Immingham Green Energy Terminal – TR030008

Section 51 advice regarding draft application documents submitted by Associated British Ports by 23 May 2023

Drawing Number
 GH-20156600001-LP-6
 Revision
 1

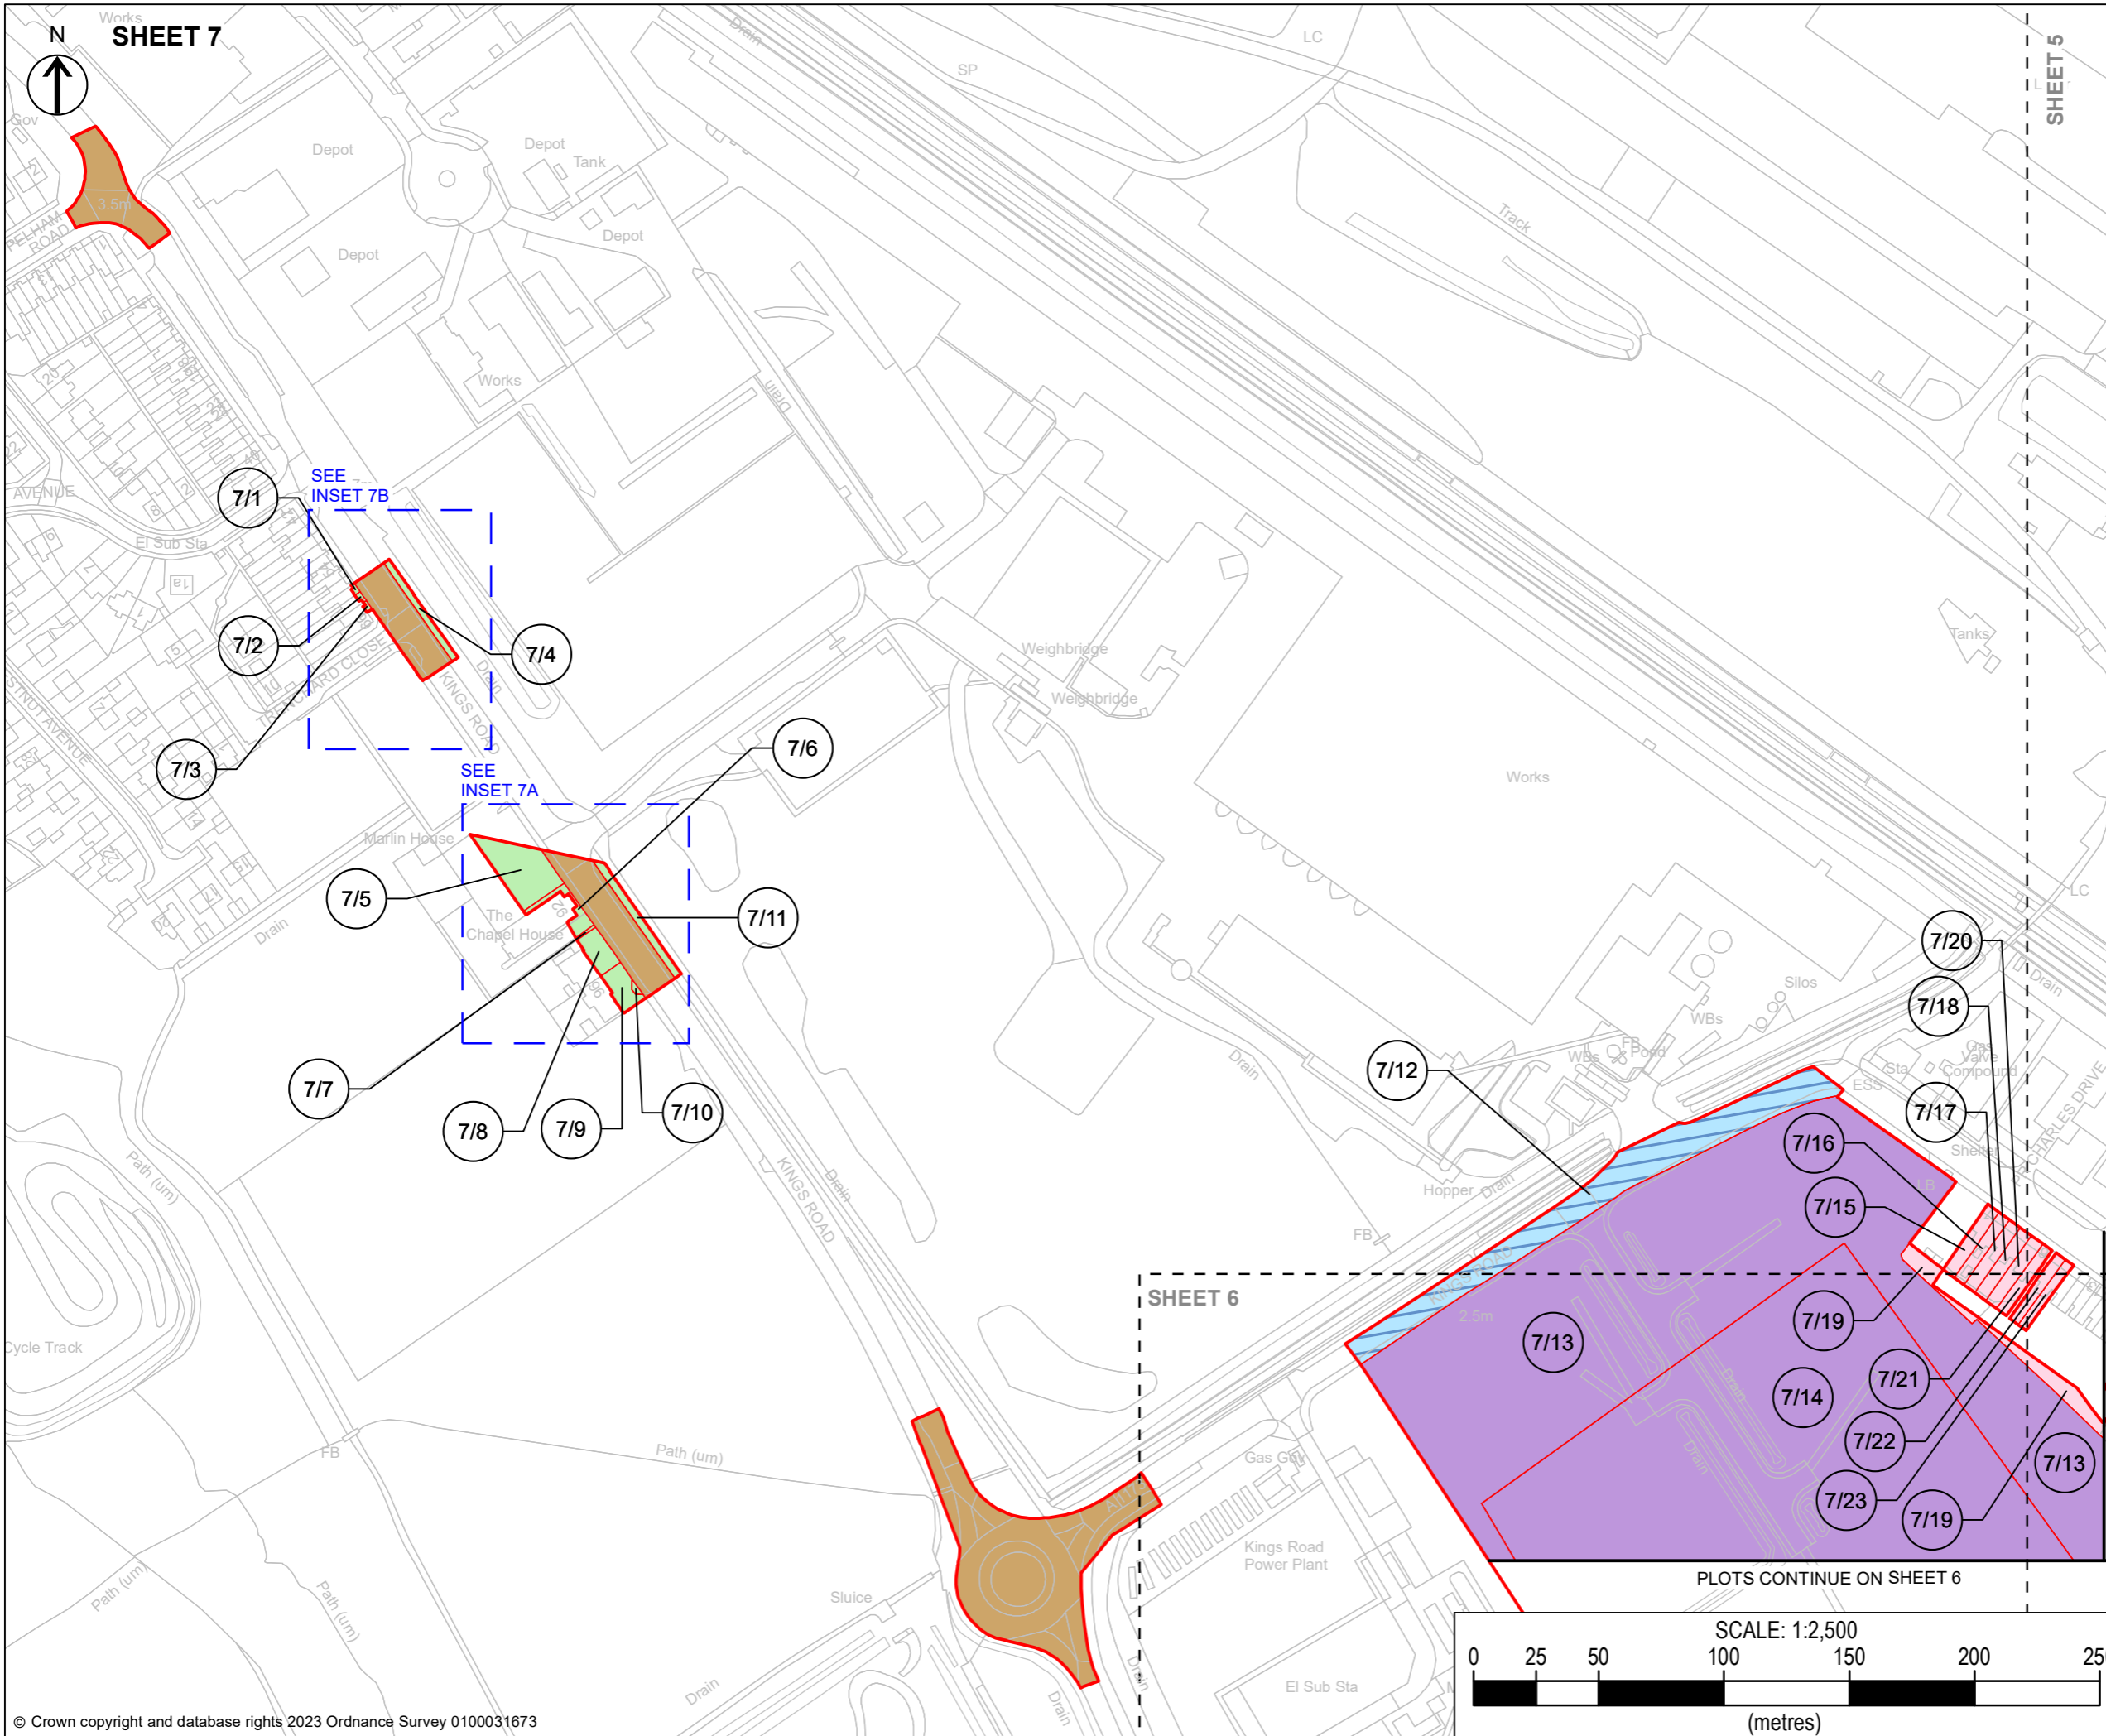
36.	Sheet 6 of 6	Inset 6C and 6D has been provided to illustrate the entirety of Works No.10. The Applicant may wish to take a common approach by including the entire junction known as Works No.10 into inset 6B.

Land Plans		
Ref No.	Plan ref	Comment/Question
37.	Sheet 6 of 6	Plot 6/1 is described in the BoR on Pelham road, however this is not illustrated on Land Plan Sheet 6 of 6, should it not instead reference “west of Kings Road”?
